Appendix 8 – Consultation Responses - Proposed Changes

Drax Bioenergy with Carbon Capture and Storage

Changes Application Report

Document Reference Number: 8.5.3.8

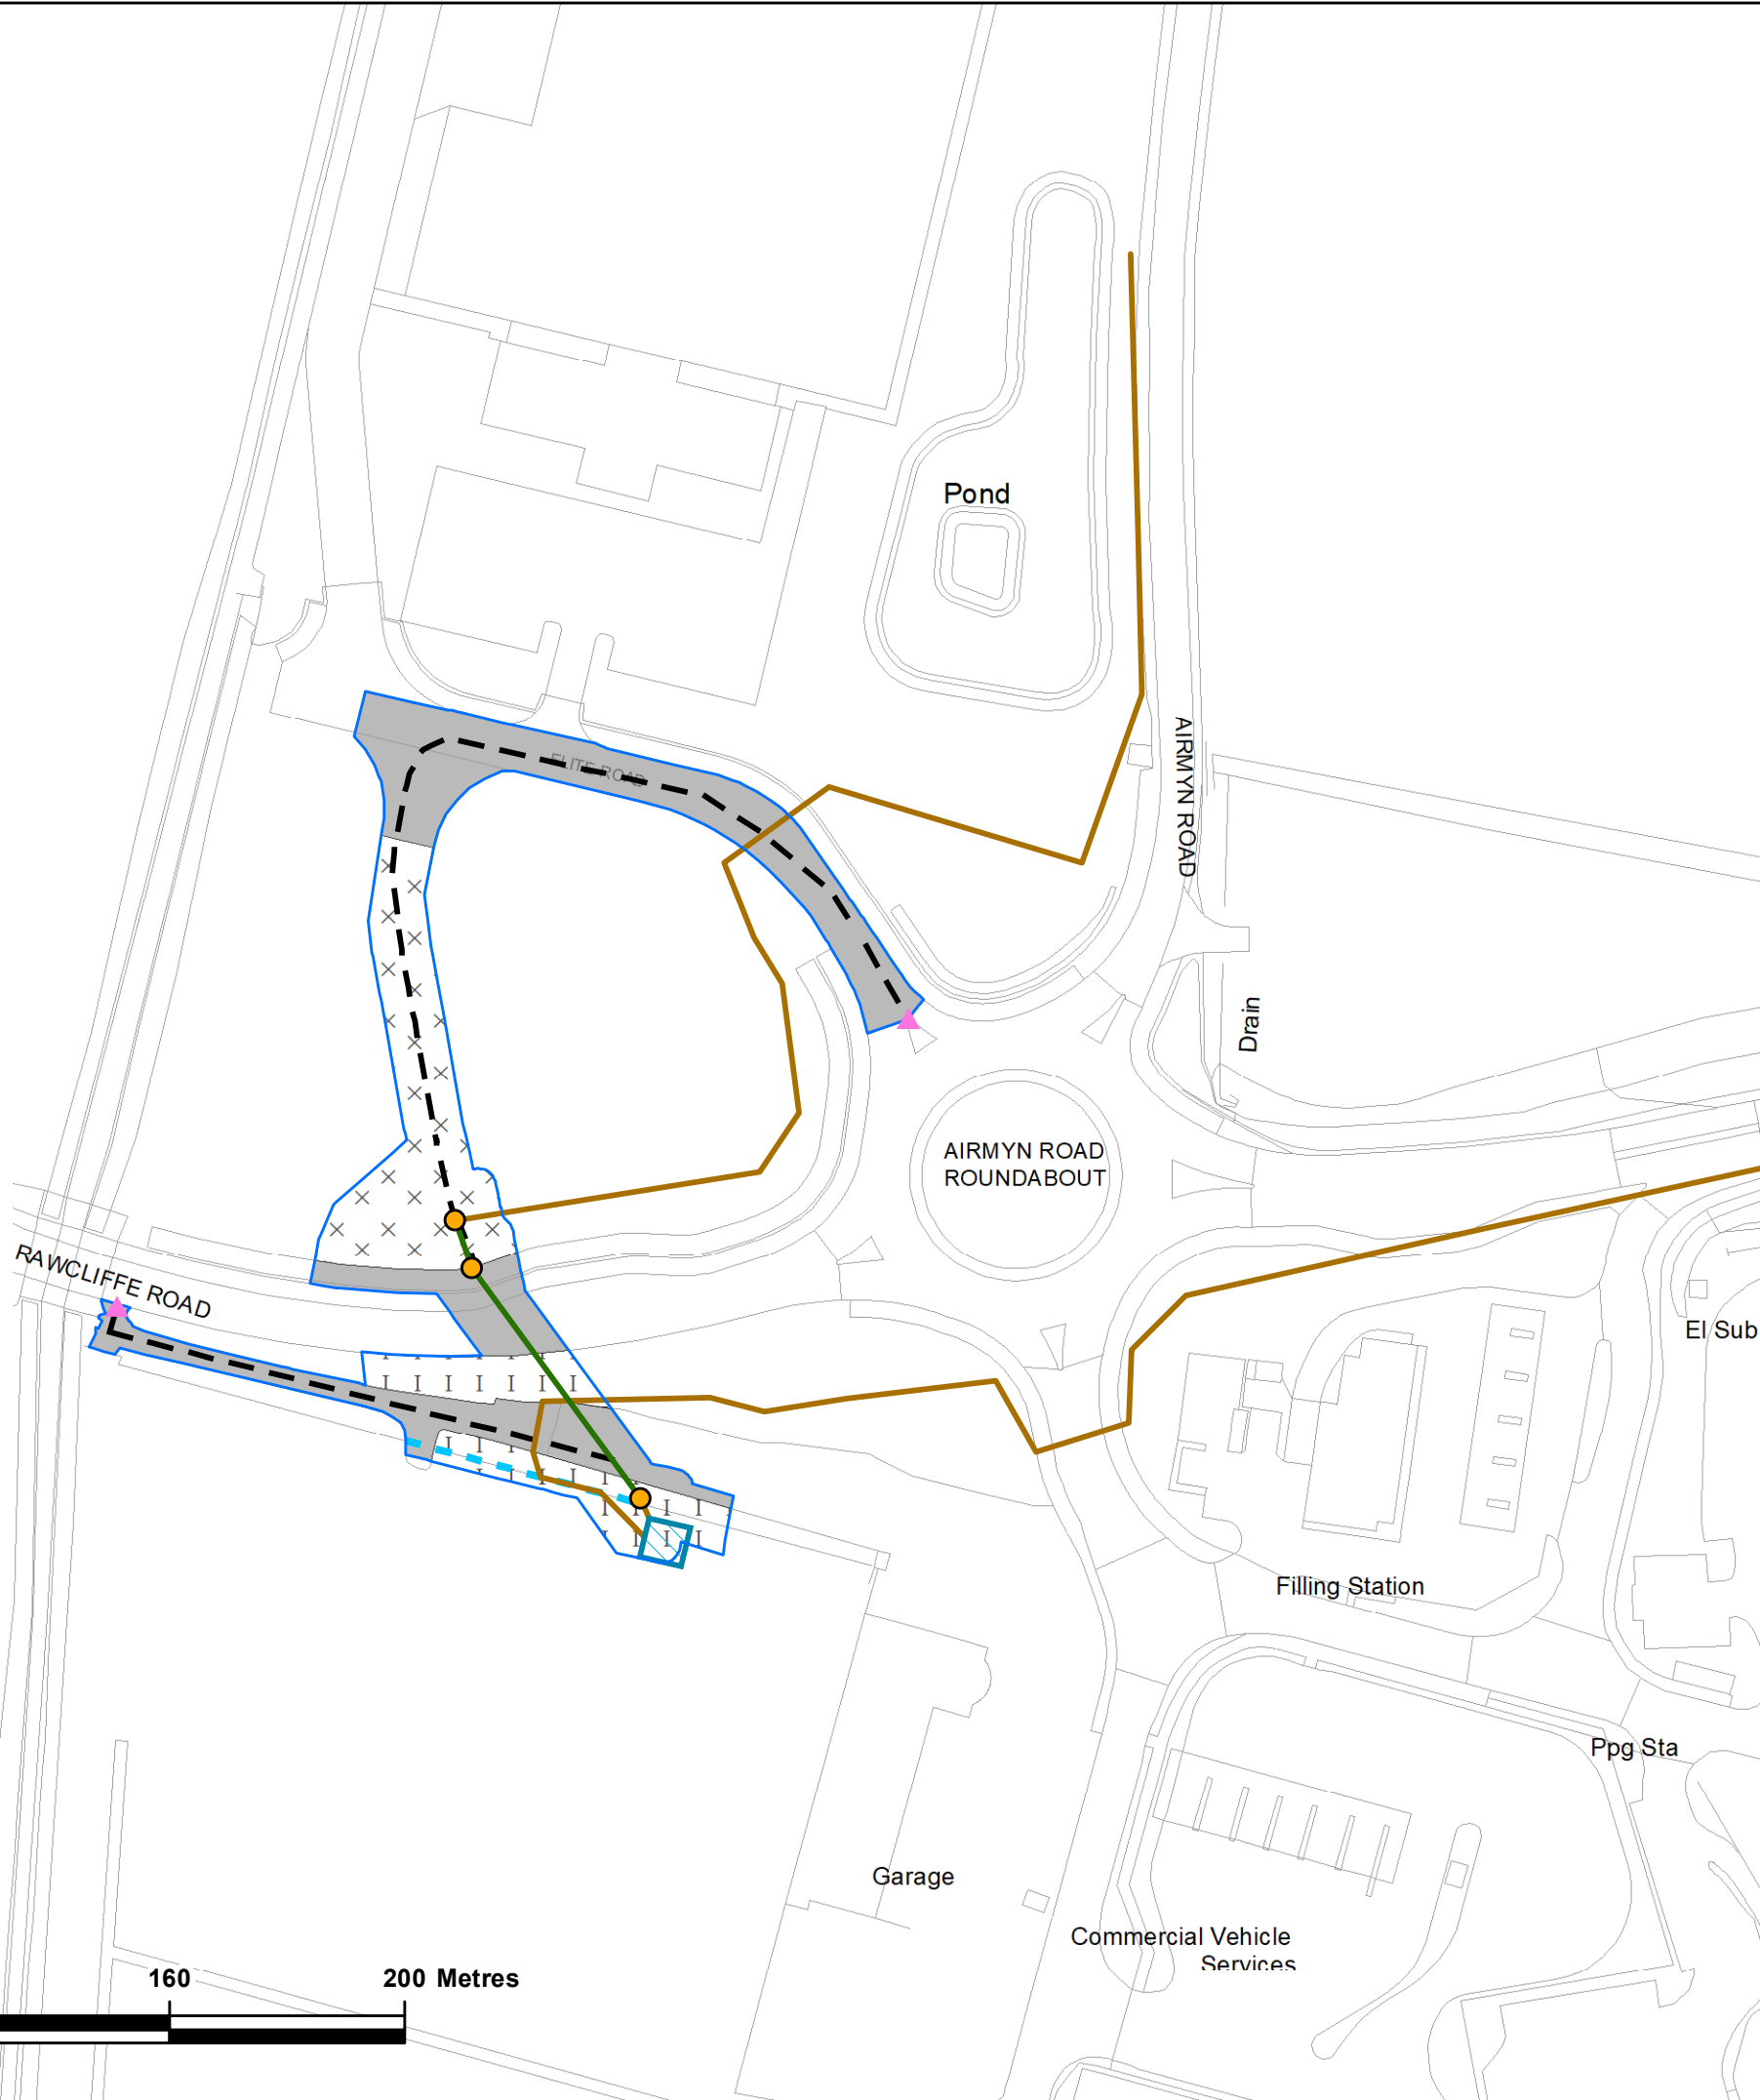
Z1	JRS Services (Leeds) Limited	The area for the proposed OHL would encroach on land that we own, and this land has the benefit of a planning consent for commercial development. Therefore, this proposed change is unacceptable to us.	The Applicant has taken on board this comment and has reviewed the consultee's planning application to understand where the potential overlap positions are. Discussions are being progressed with the asset owner of OHL2 on the design of a solution for undergrounding works and will seek to minimise the impact on these land interests. In this regard the Applicant is in further detailed discussions with Northern Powergrid to investigate design options to minimise impact.

<p>The Applicant will endeavour to minimise impact on the interested party's proposed development site, and welcomes ongoing engagement with the interested party to keep them updated on discussions with Northern Powergrid regarding the design options for the undergrounding works to OHL2.</p> <p>A C4 request for a detailed design and cost estimate of necessary works to underground OHL2 (and OHL1) has been requested from Northern Powergrid, and the parameters for the design requested were revised following the receipt of the interested party's comments and a review of the proposed site layout for the application referred to by the interested party. The updated illustrative design parameters included with the updated request to Northern Powergrid are shown in Plates 6-2 and 6-3.</p> <p>We understand that East Riding of Yorkshire Council has delegated approval for an employment development on land south of Rawcliffe Road (A614), subject to the signing of a legal agreement. We understand that the Decision Notice for the proposed employment development had not yet been issued pending the finalising of the legal agreement at the date of writing this response.</p> <p>The Applicant, and the Applicant's land agent will progress engagement with the interested party to address the issues raised in the detailed design of the proposed works to OHL2.</p>
